Contact Name: Mathew Pringle
Contact No: (02) 6540 1139
Our Reference: OUT-515/21

29 January 2021

Hills of Gold Wind Farm (SSD-9679) - Environmental Impact Statement

Hills of Gold Wind Farm Map

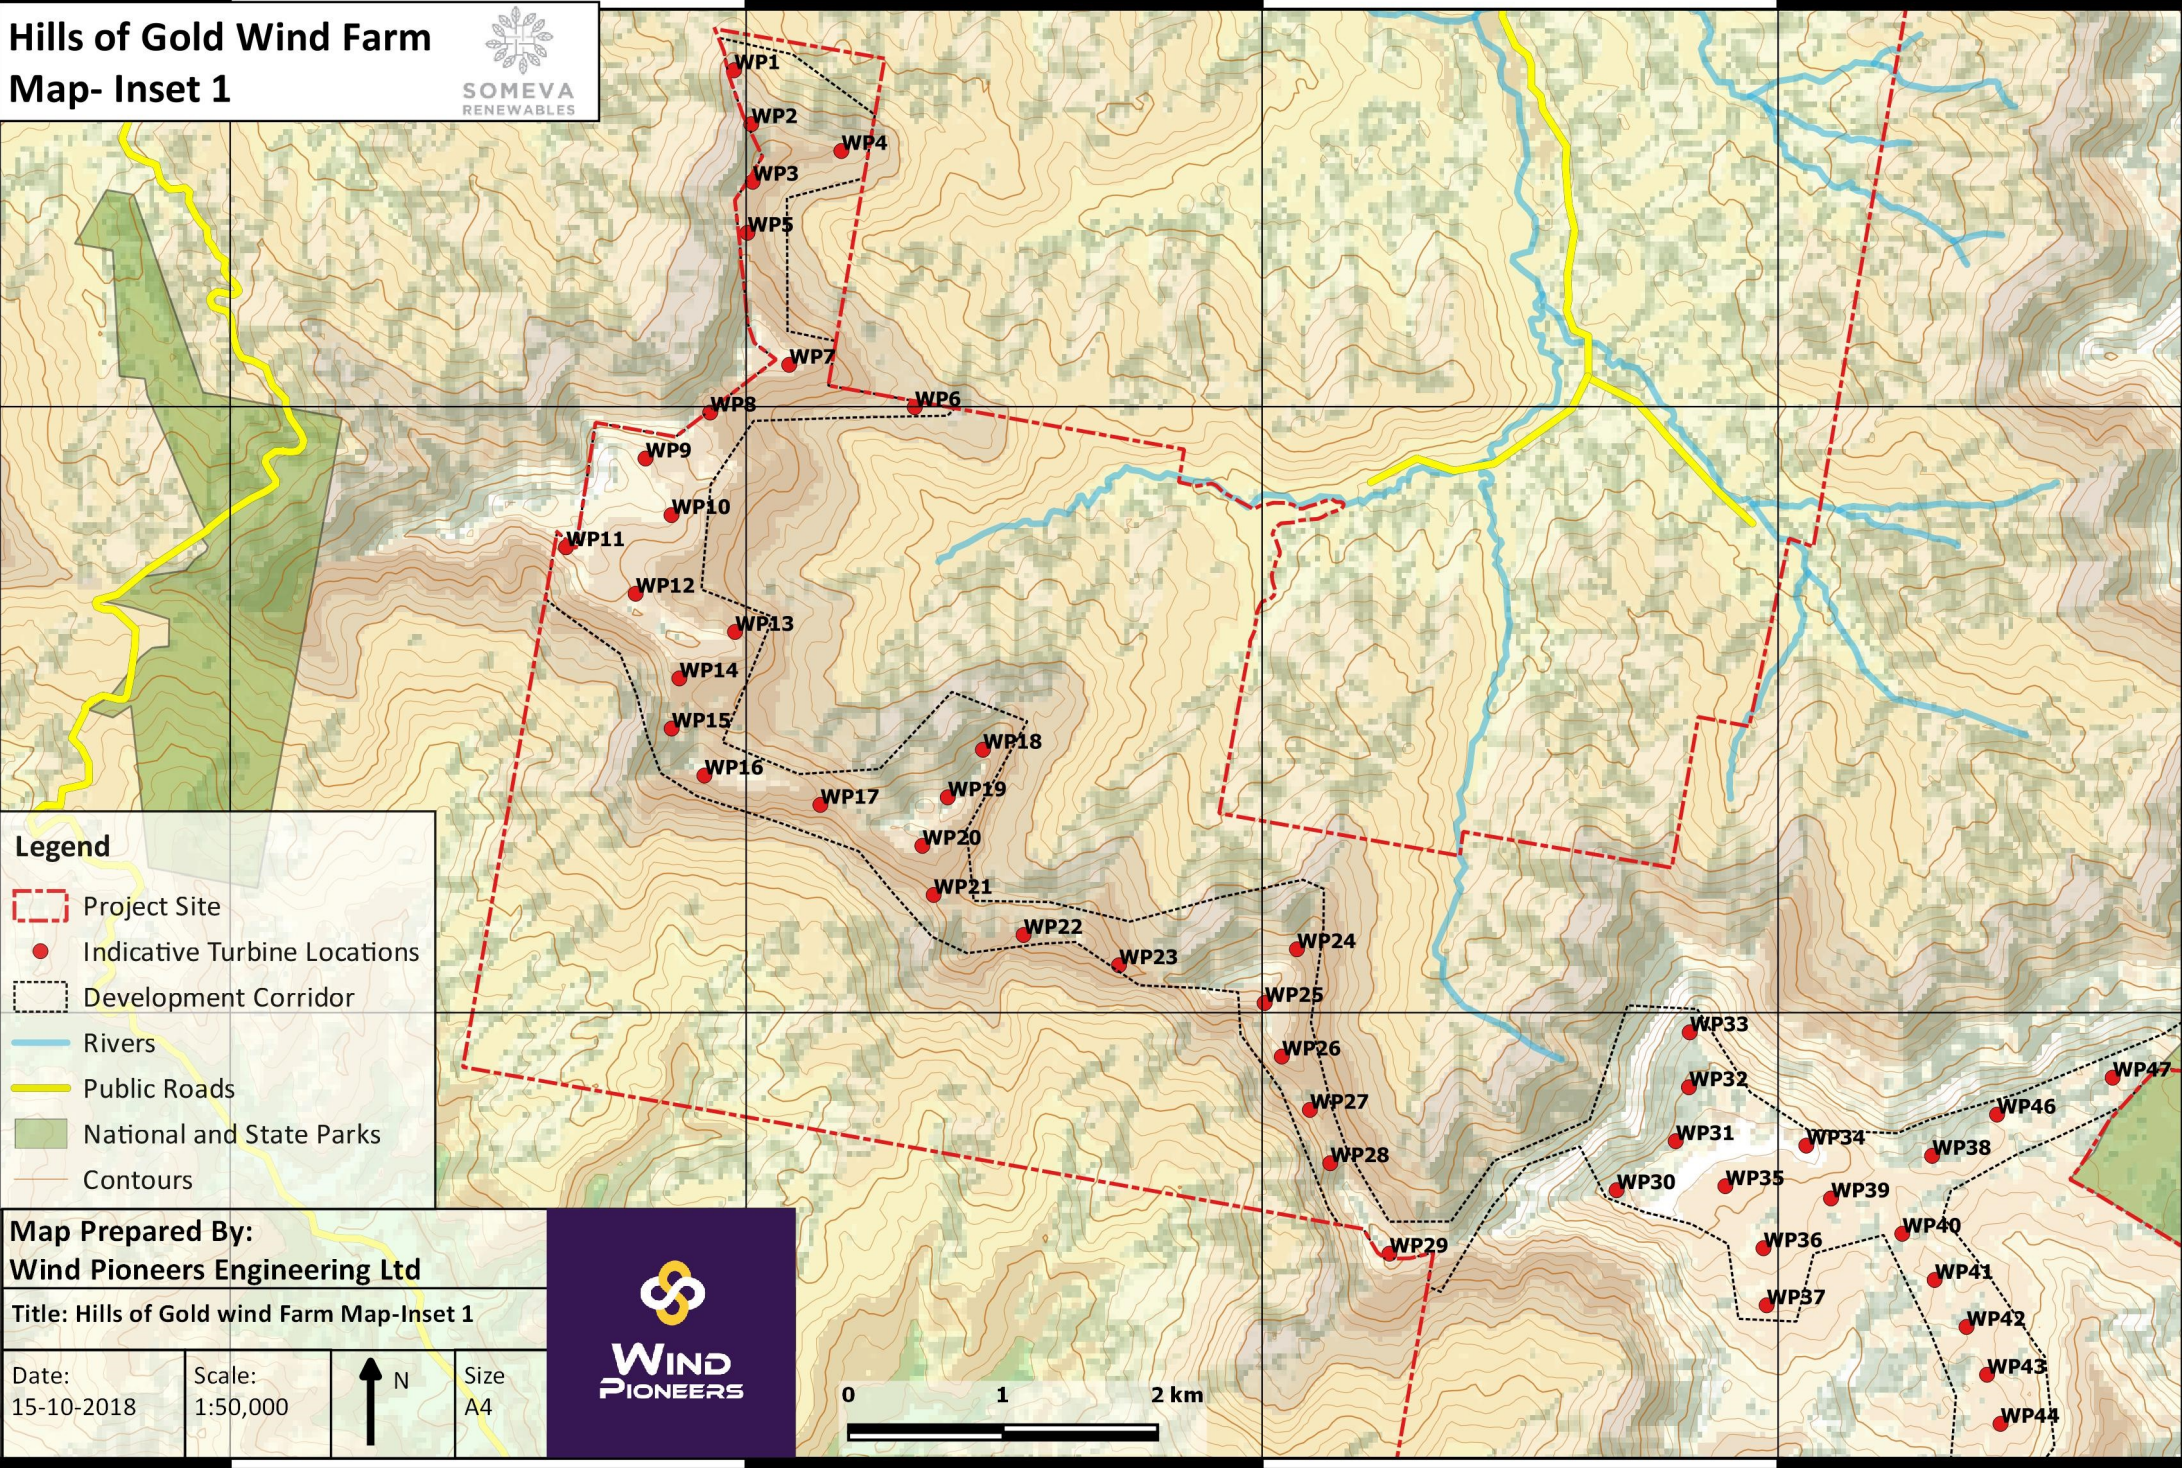
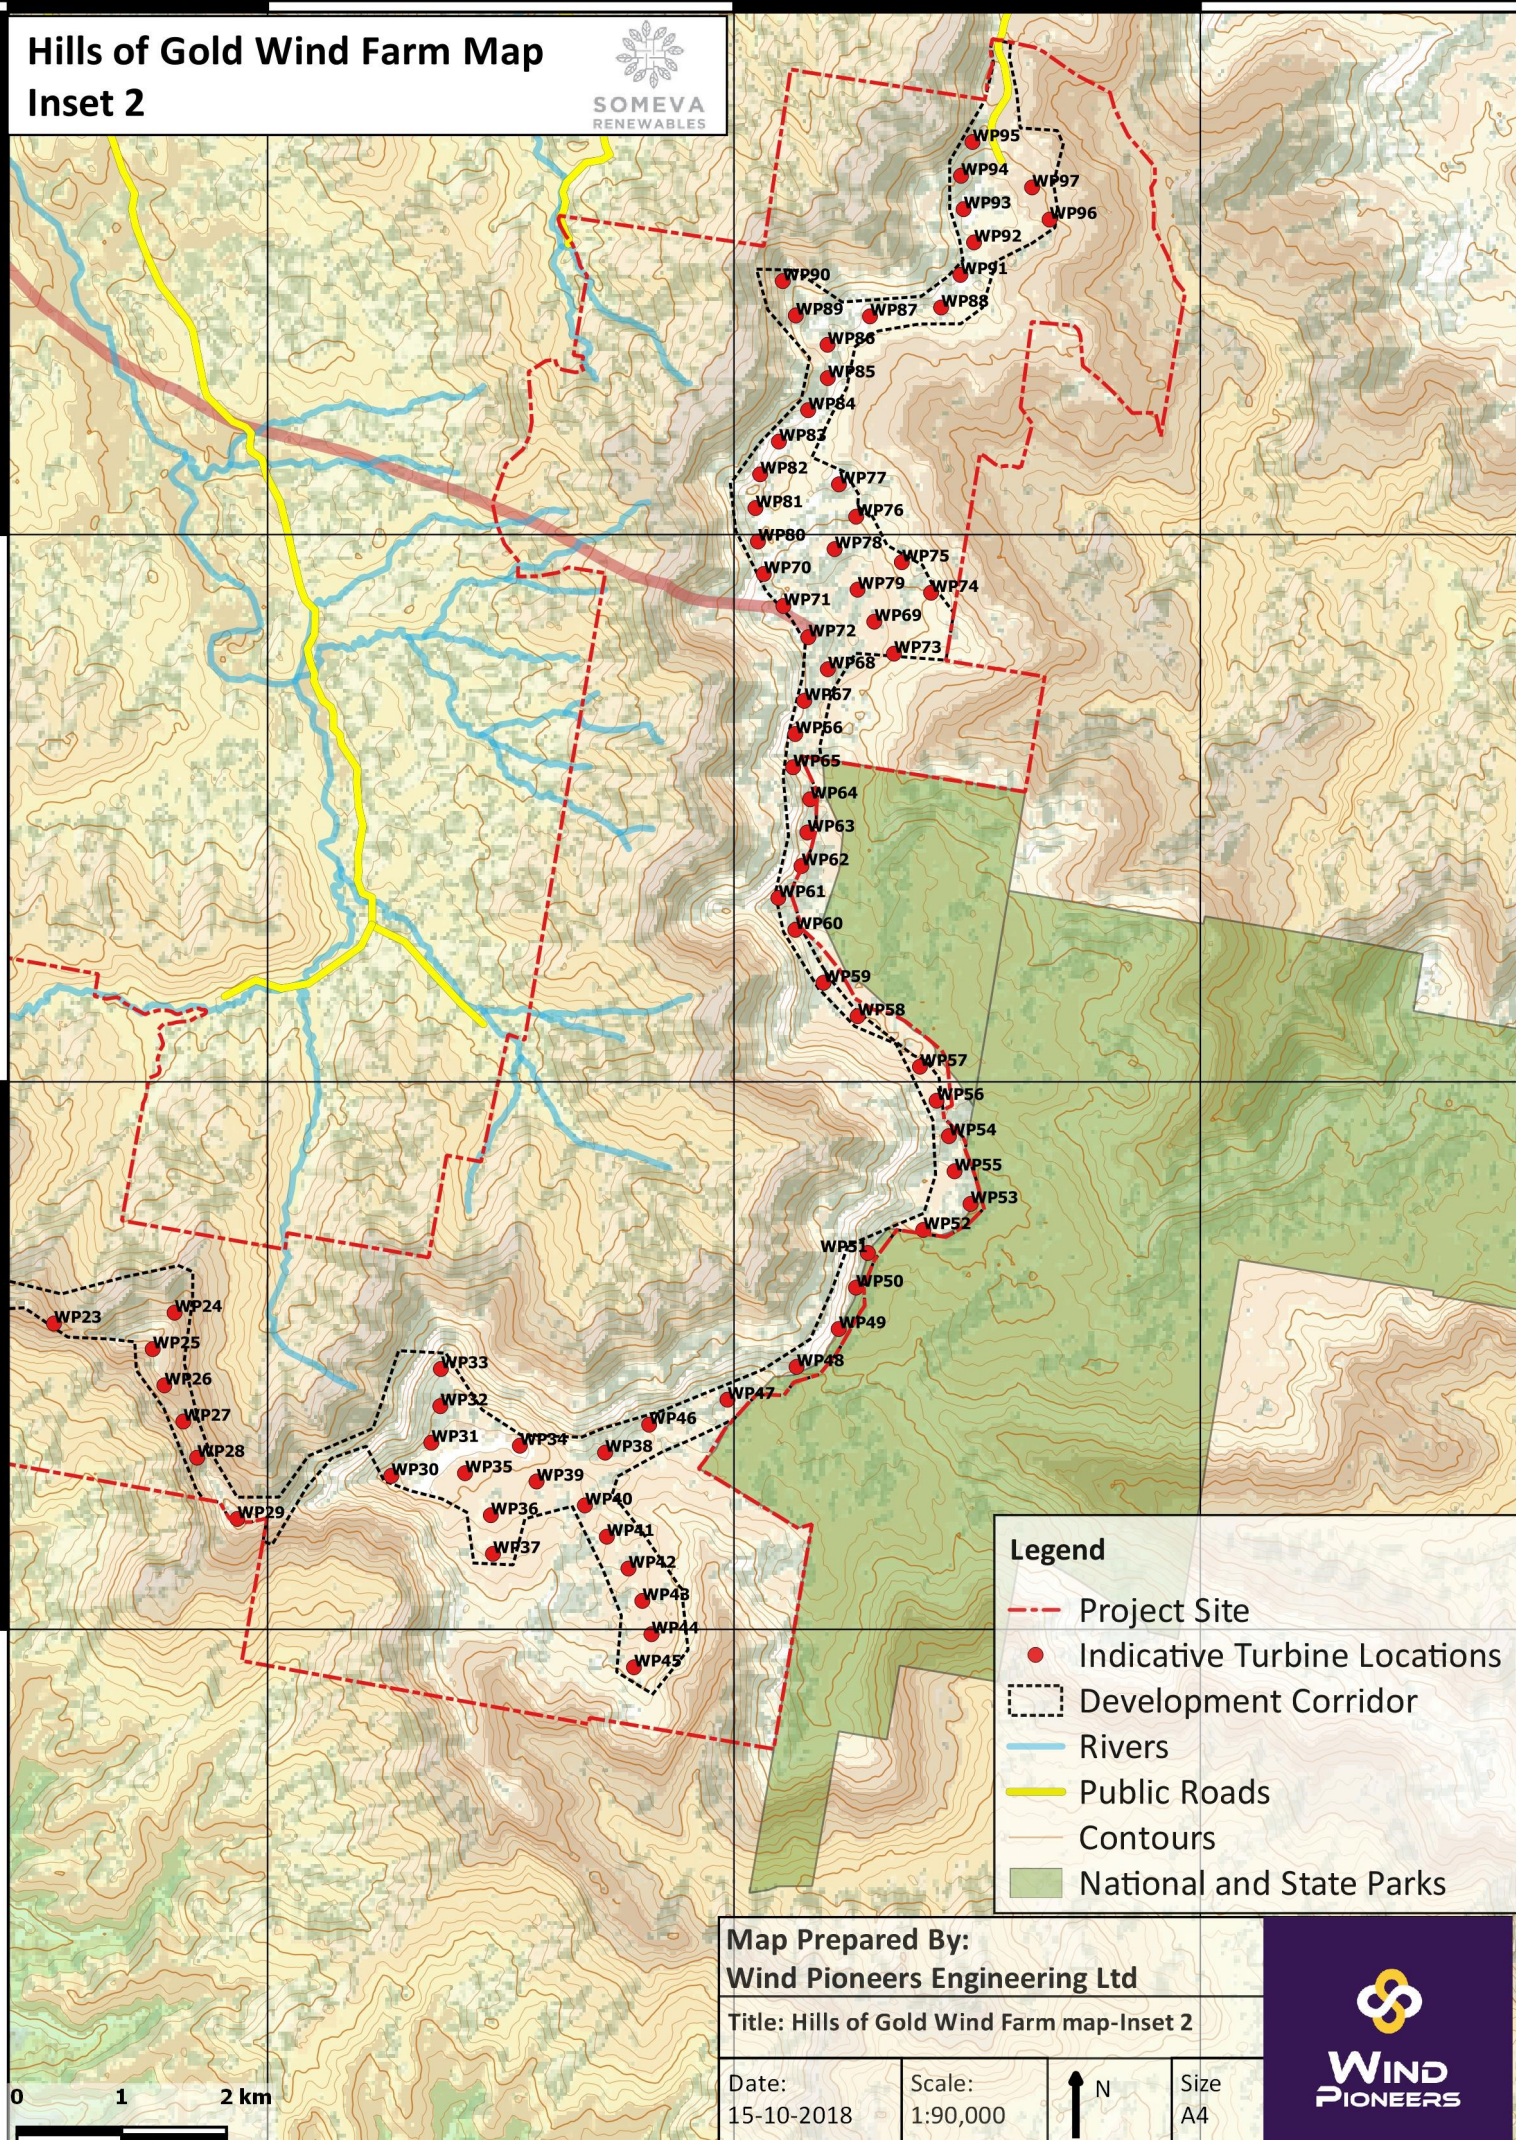
A review of the visual impact assessment raises some concerns in relation to the visual impacts of the wind farm on properties within the Upper Hunter Shire LGA. The proposed wind turbines are densely spaced along the ridgeline forming the LGA boundary and will be highly visible from a number of properties. Consideration should be given to reducing the number of turbines and/or increasing the spacing of the turbines in areas where they are highly concentrated (eg. WP20 – WP39) to mitigate the potential visual impact.
